From: Michael Eastham <Michael.Eastham@arun.gov.uk>
Sent: 22 April 2021 15:58
To: Planning.Responses <Planning.Responses@arun.gov.uk>
Subject: FW: *EXTERNAL: FW: Water Lane, Angmering - Cond. 9; Noise (Ref. A.39.21.DOC)

Please upload onto Ocella the email below which is a consultation response from **ADC Greenspace** to **A/39/21/DOC**.

From: Sue Howell <Sue.Howell@arun.gov.uk>
Sent: 22 April 2021 15:51
To: Michael Eastham <Michael.Eastham@arun.gov.uk>
Subject: RE: *EXTERNAL: FW: Water Lane, Angmering - Cond. 9; Noise (Ref. A.39.21.DOC)

ANGMERING - EASTERN BUFFER, ACOUSTIC FENCE

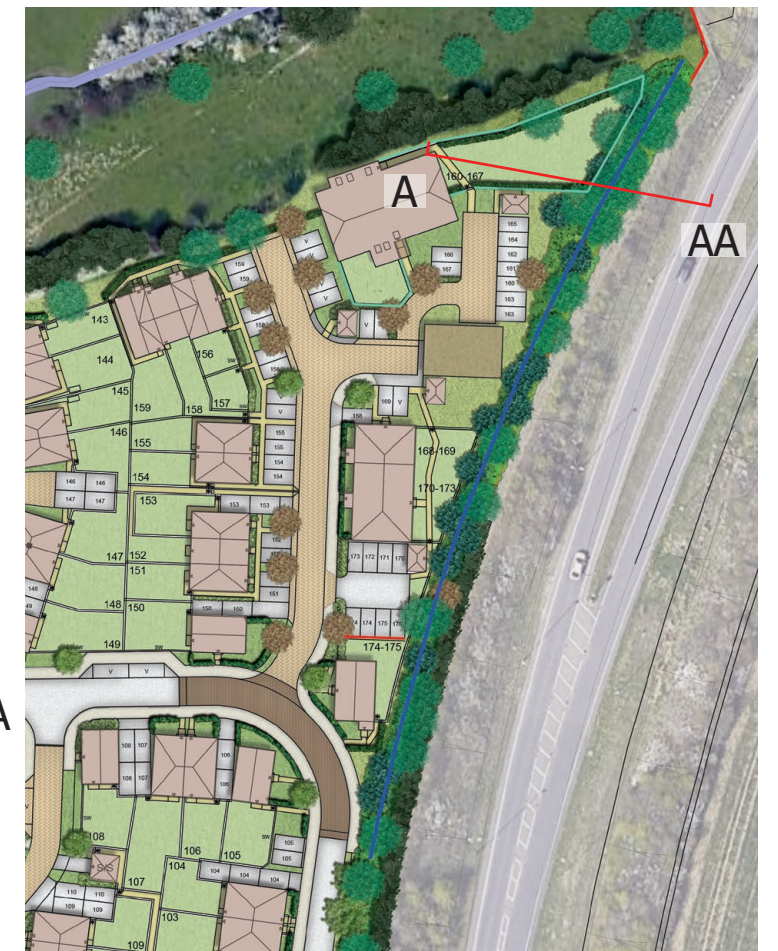
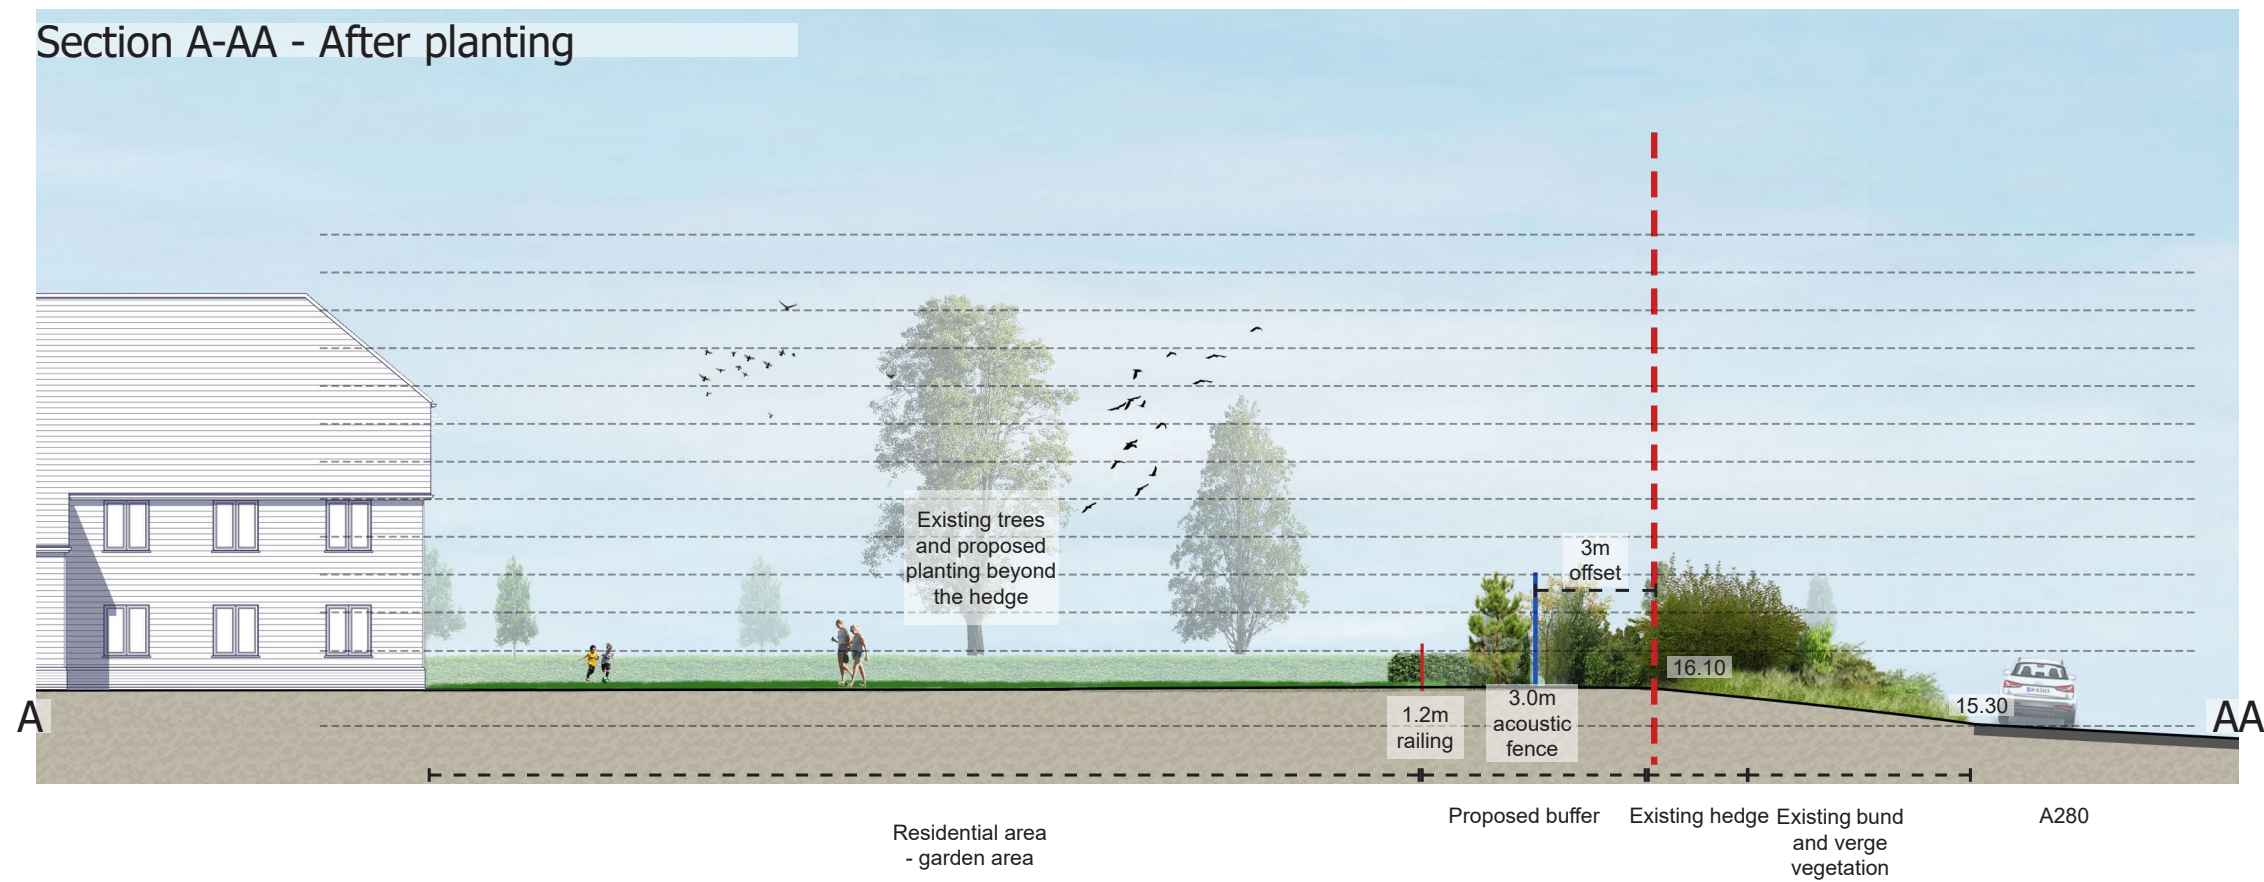
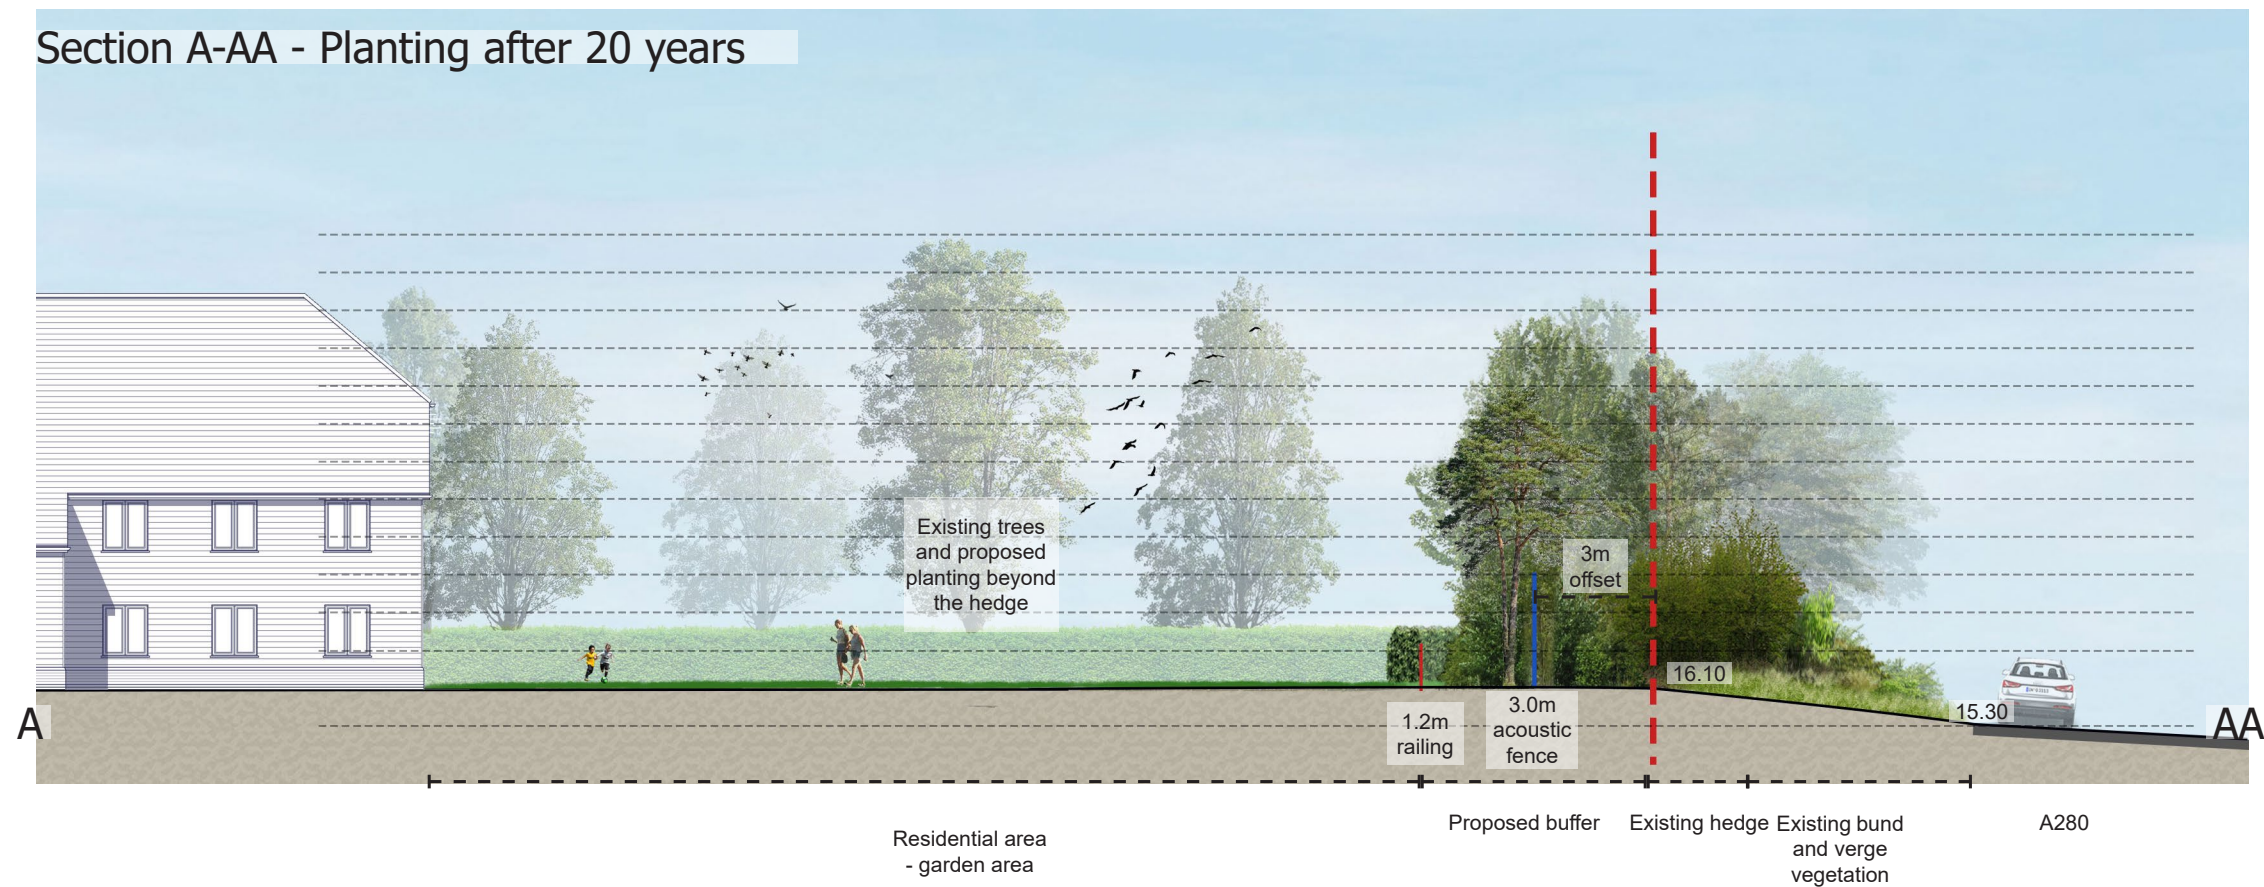
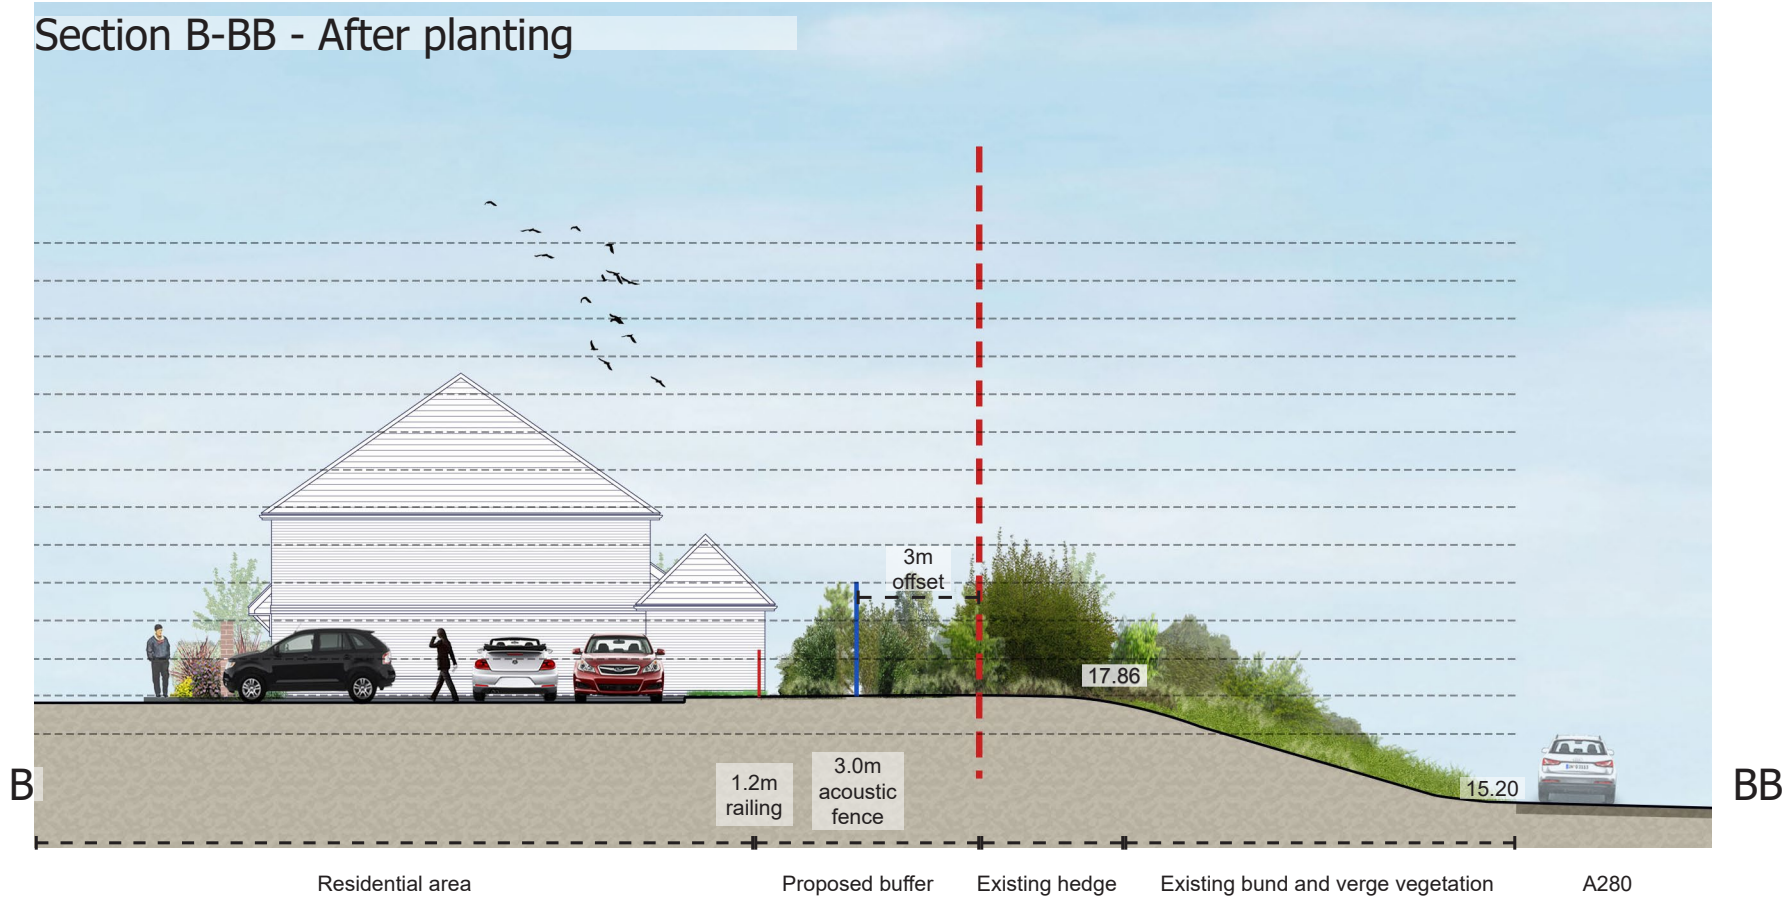
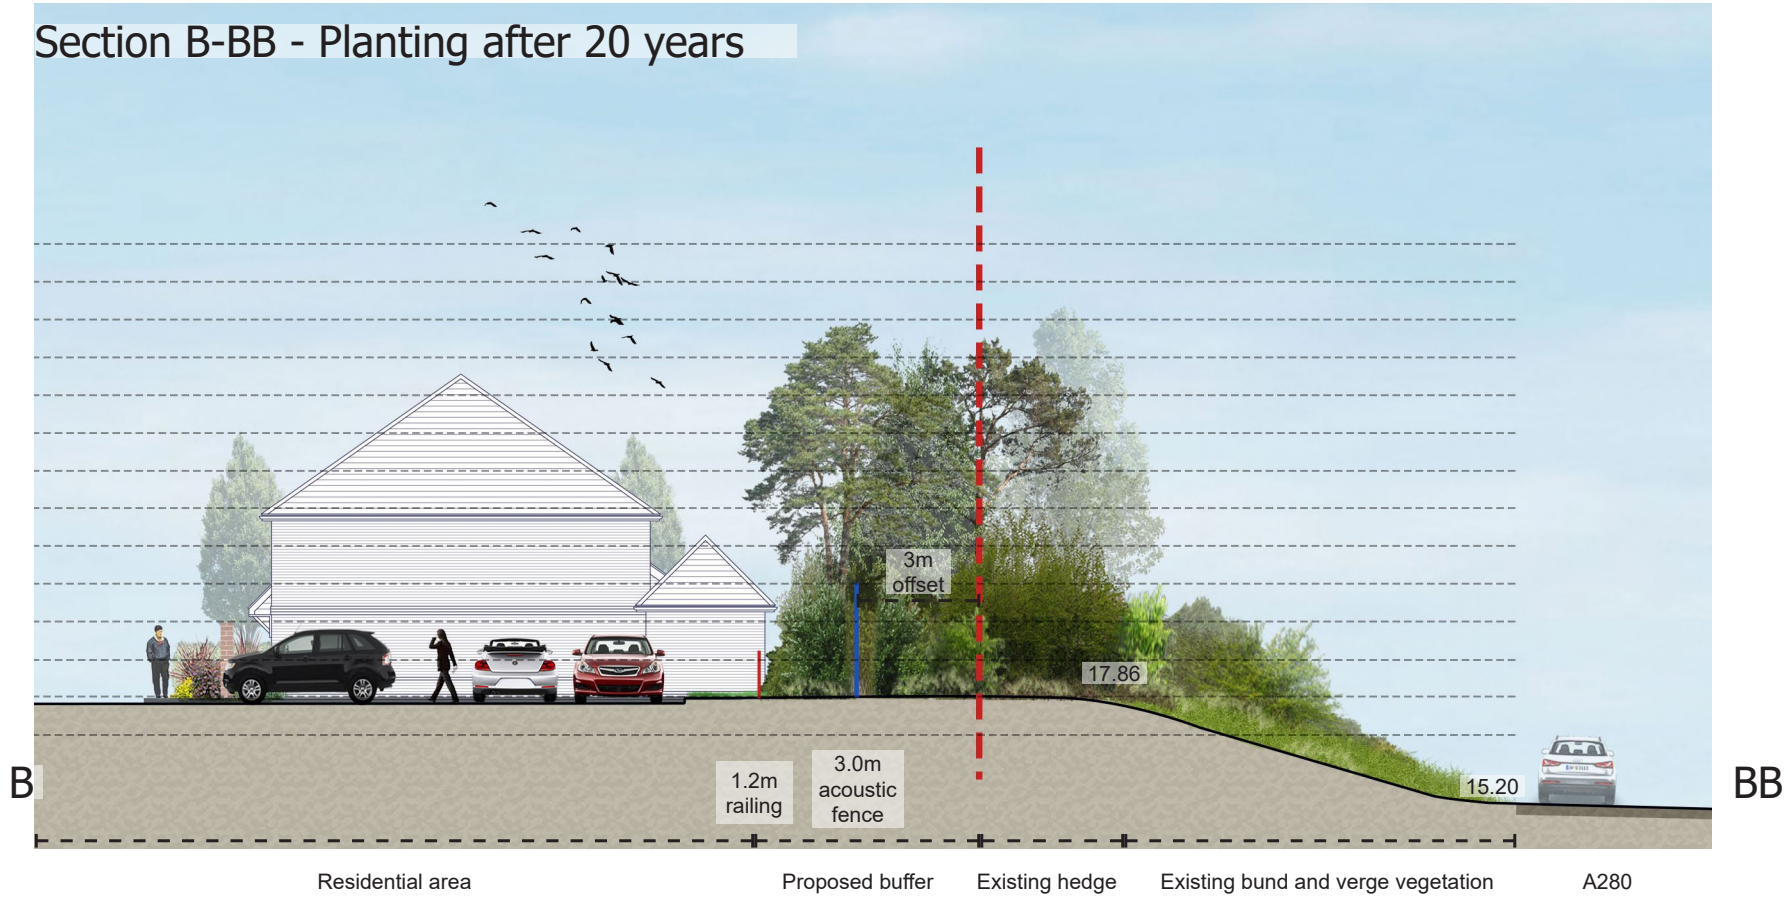
The **ILLUSTRATIVE SECTIONS ANGMERING - EASTERN BUFFER, ACOUSTIC FENCE** April 2021 document refers to 3m offset from acoustic fence...to what? the boundary fence? What happens in this offset area? I assume it will be planting? But this needs to be shown in plan form to illustrate what effect the acoustic fence will have on the already agreed proposed planting in this area? Will

there be a reduction in planting here to accommodate the barrier? Will there need to be a service strip between planting and barrier?

The documents attached are illustrative but don't give a clear picture. Assuming planting will be both development side and road side of the barrier? but this needs to be confirmed in plan form to clearly show this .Please request from the developer further clarity (not just illustrative) of the detailed planting interface along the proposed barrier.

The 3m offset is from the Acoustic Fence to our land ownership. This ensures that we can carefully manage the planting on both sides of the fence to ensure that the anticipated landscaping buffer is retained. To further illustrate this, please find Detailed Planting Plans 2 and 3 illustrating the location of the barrier and the 0.5m buffer either side to allow for maintenance. Please find these drawings within the WeTransfer link above.
